Application No: FG/82/21/PL
Site Address: 11 Ferring Marine Ferring BN12 5PP
Description of works: Variation of condition imposed under FG/127/19/HH relating to approved plans.

Thank you for your internet representation made on 4th June 2021 which has been recorded as an objection with the comments as follows:

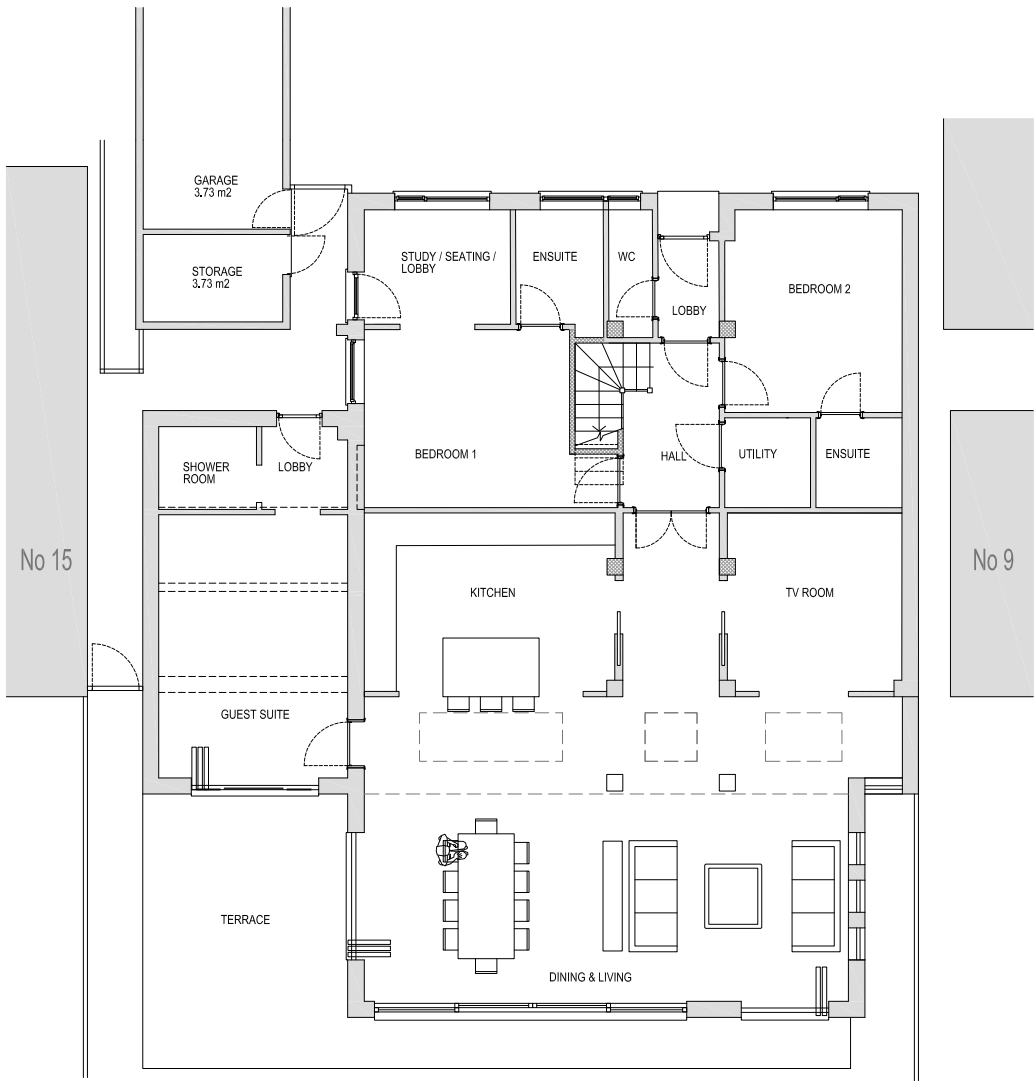
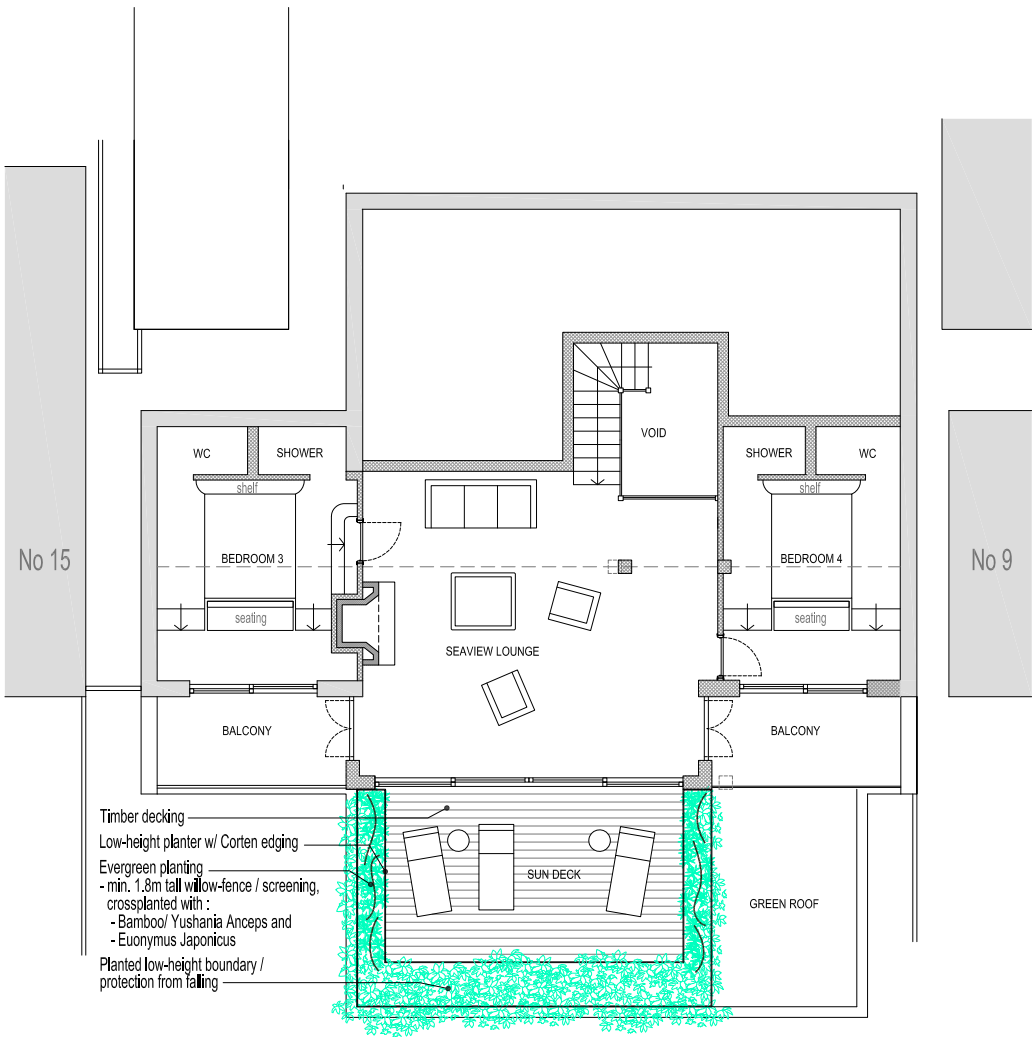
I request that you please decline the application in its entirety. Allowing any additional balcony than what he has already has permission for will bring his balcony far forwards in front of all the other balconies along the road, allowing a significant invasion of privacy including seeing into my little boy's bedroom, seeing him playing in the garden and overlooking all other neighbours. Most significantly, it will block nearly all the sunlight in my garden. He has already taken half my sunlight, he should not be allowed to take the rest.

PROPOSED
ELEVATIONS AND
MAIN SECTION

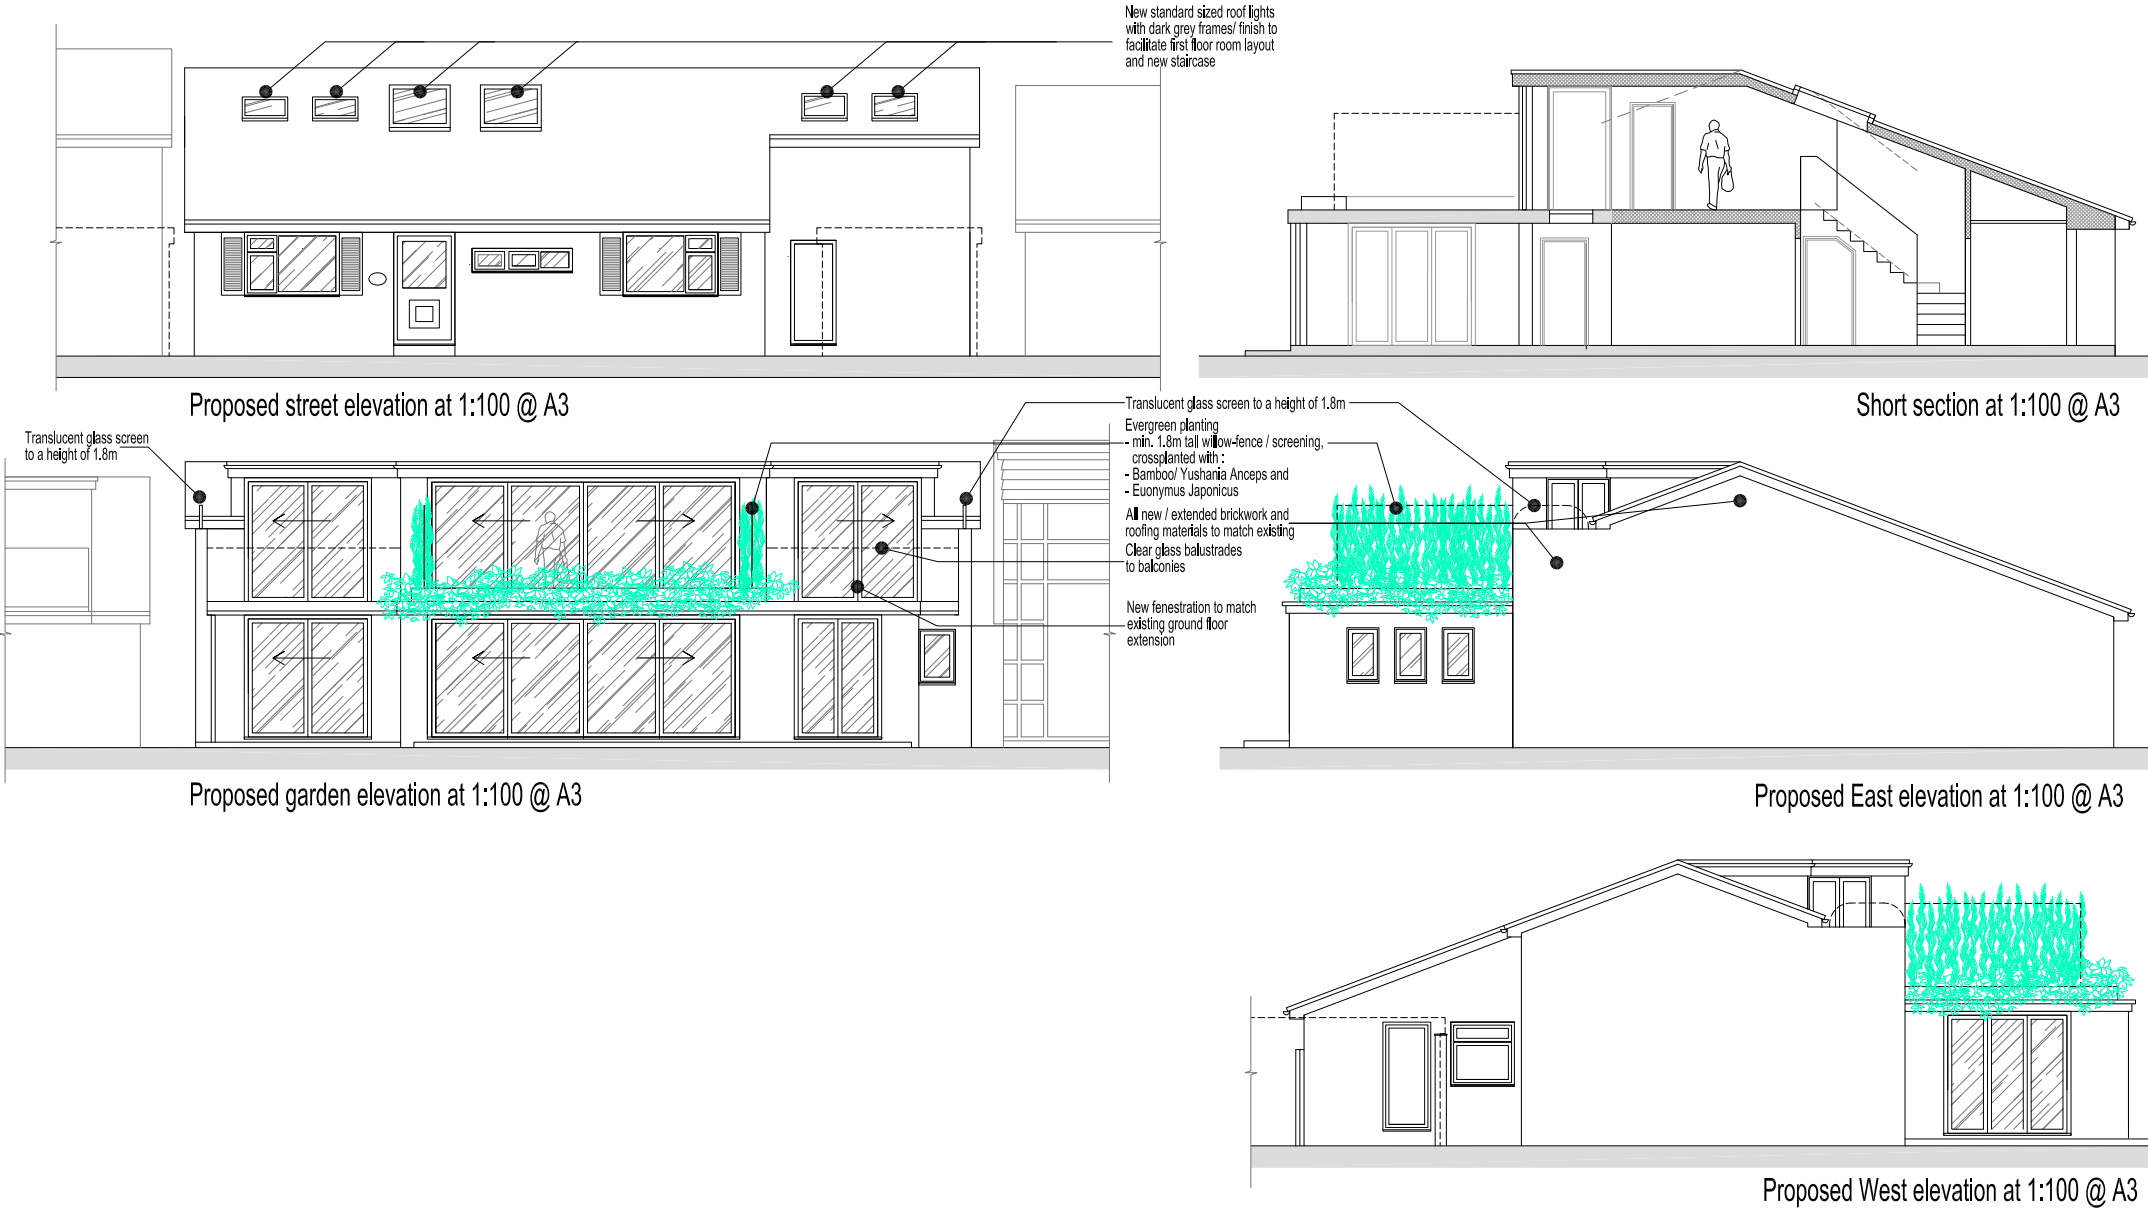
The proposed plant-based screening will be damaged/have sections blow away by wind, further and significantly exacerbating the privacy issues. Many violations of the current planning permission have already been built and the balcony that has already been built is already significantly larger than that which permission is now being sought for and thus already in violation of this proposed amendment.

The local area will also suffer significantly, as doubling the height of the ground floor extension with the privacy screens will make what is already a significant eye-sore far worse when viewed from neighbouring properties, the popular public path Pattersons Walk and the beach. It will harm the local area significantly and one person's personal interest shouldn't trump the public interest of what is currently a very beautiful area and the interests of all other neighbours.
